PLANNING AMENDMENT

Application No. H23/580/02

HOUSE & DETACHED DOUBLE GARAGE

**RE: PROPOSED HOUSE AND DETACHED DOUBLE GARAGE AT CHAPELGATE
WHAPLODE DROVE FOR FENBANK BUILDERS**

FENBANK
GARAGE
FB/DG/T
1:50 1:100 | MAY-01

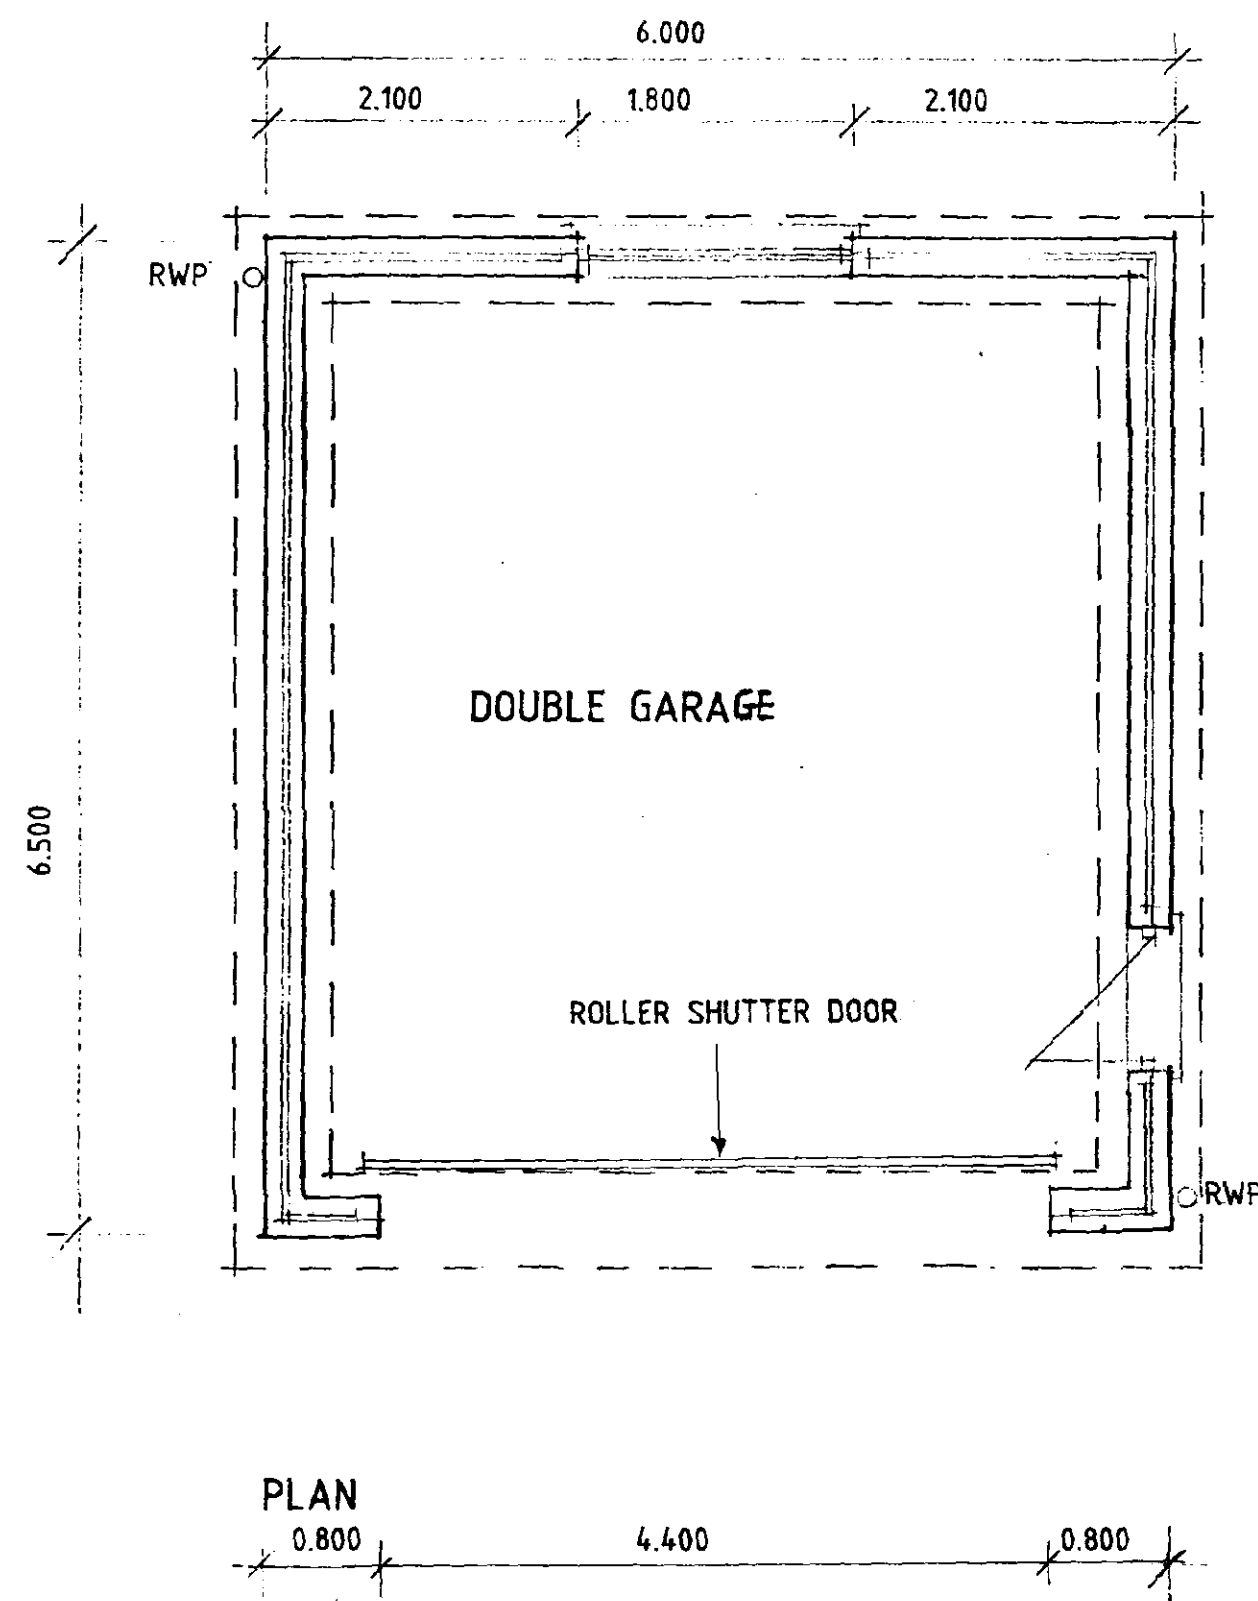
DWELLING & GARAGE RE-POSITIONED ON SITE. ROLLING SHUTTER TYPE GARAGE DOOR.

**HURRICANE
MODIFIED**

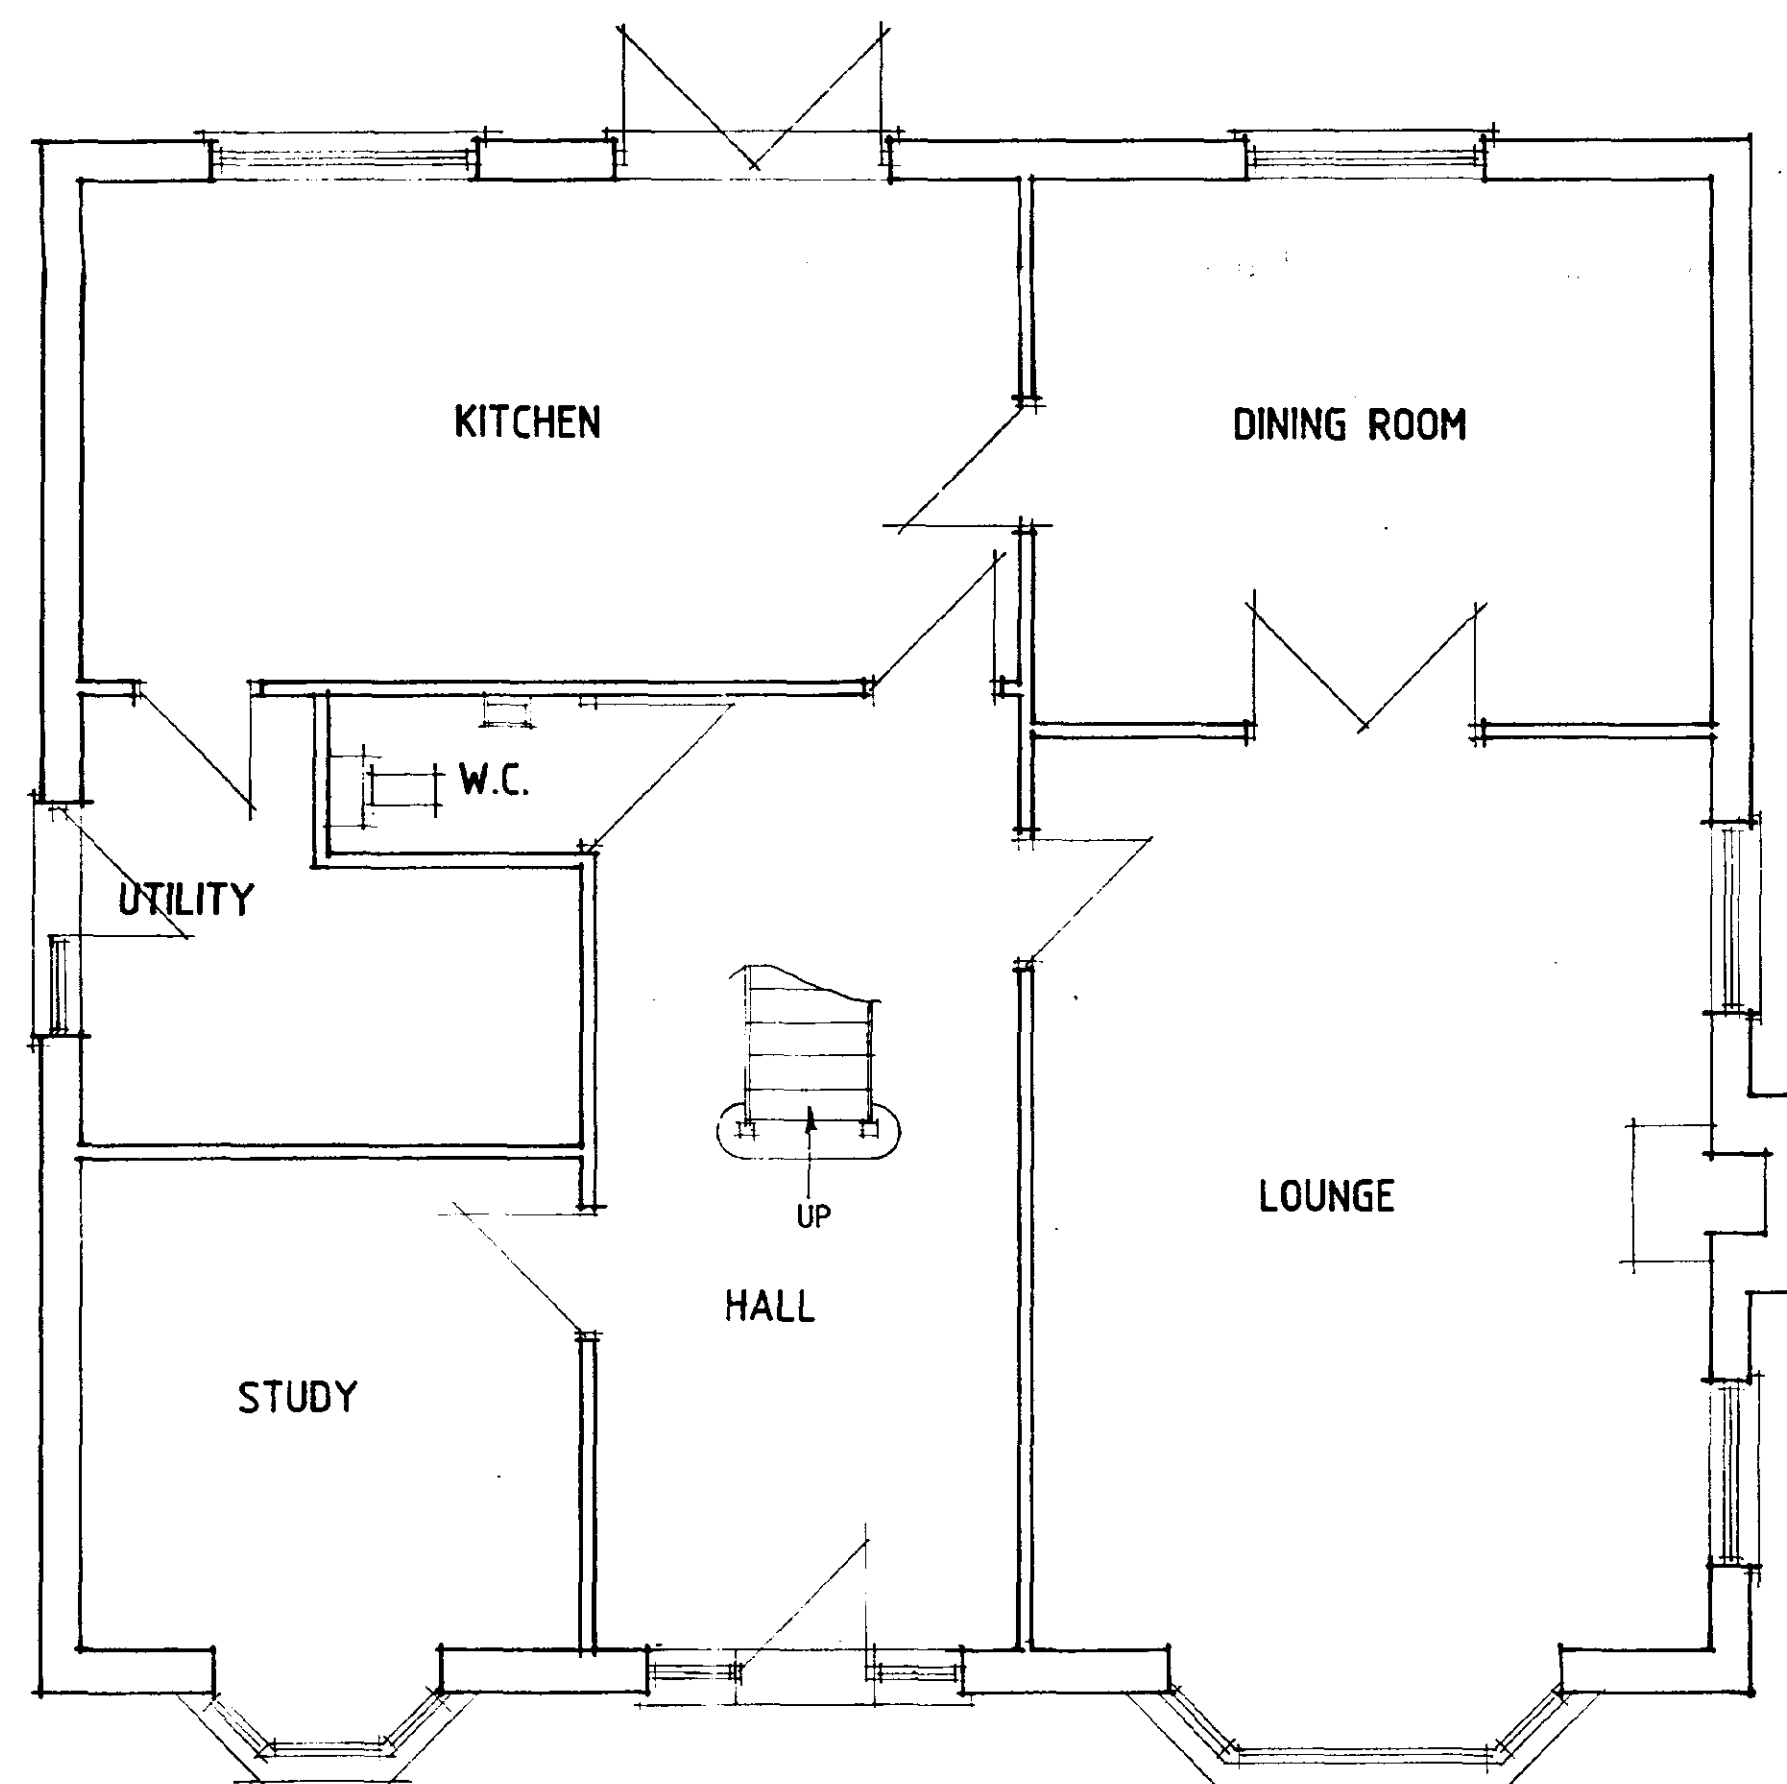
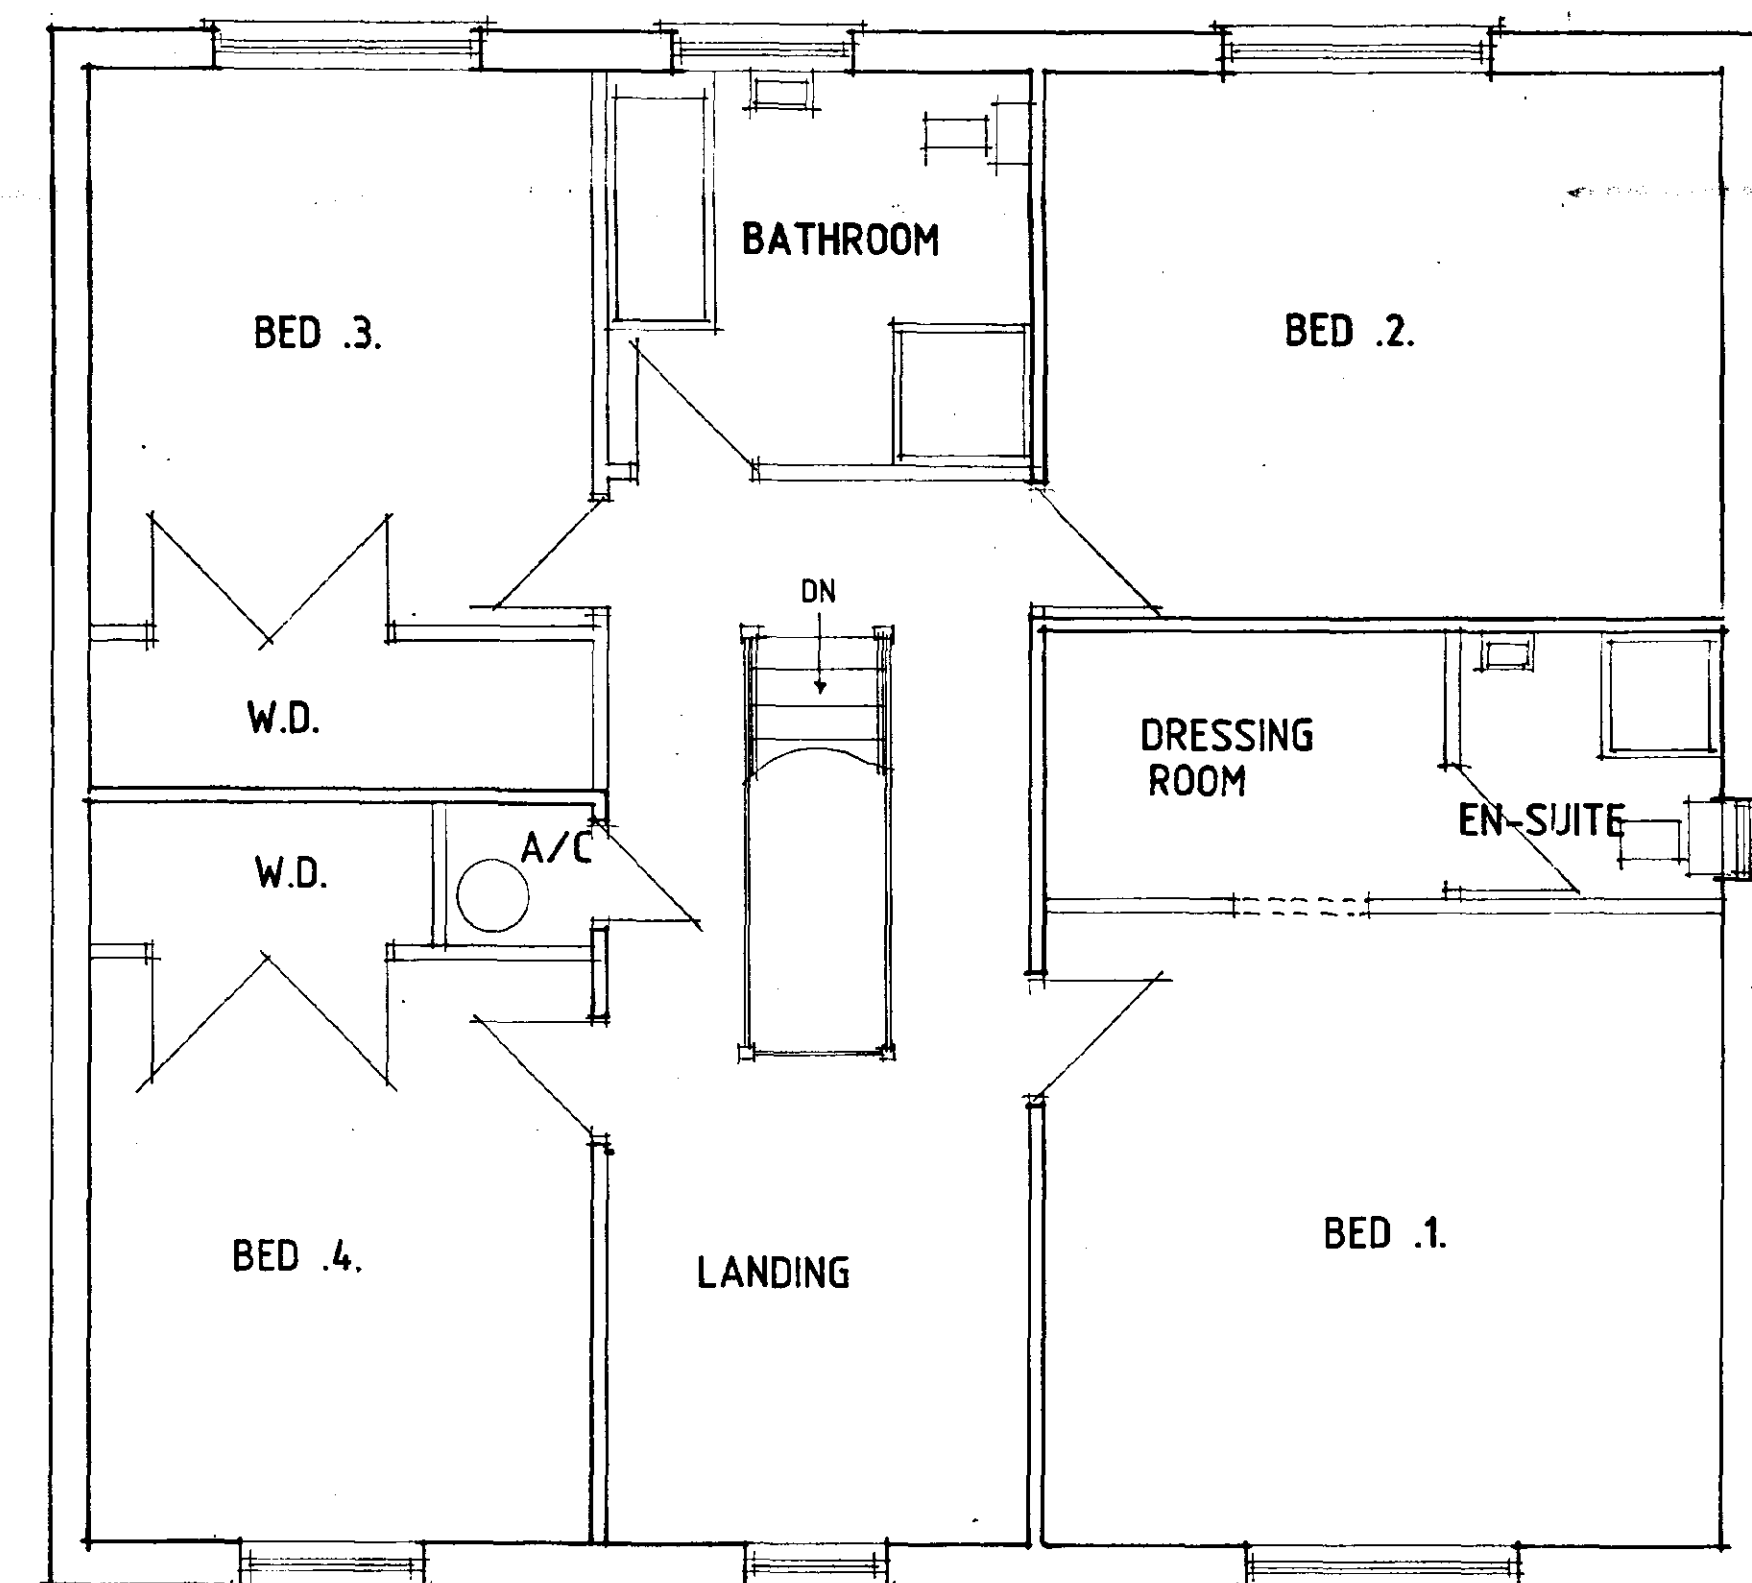
ALTERATIONS TO BED'S 3 & 4 & LANDING STAIRS TO FIRST FLOOR & HALL & STUDY/UTILITY/WC AREA TO GROUND FLOOR
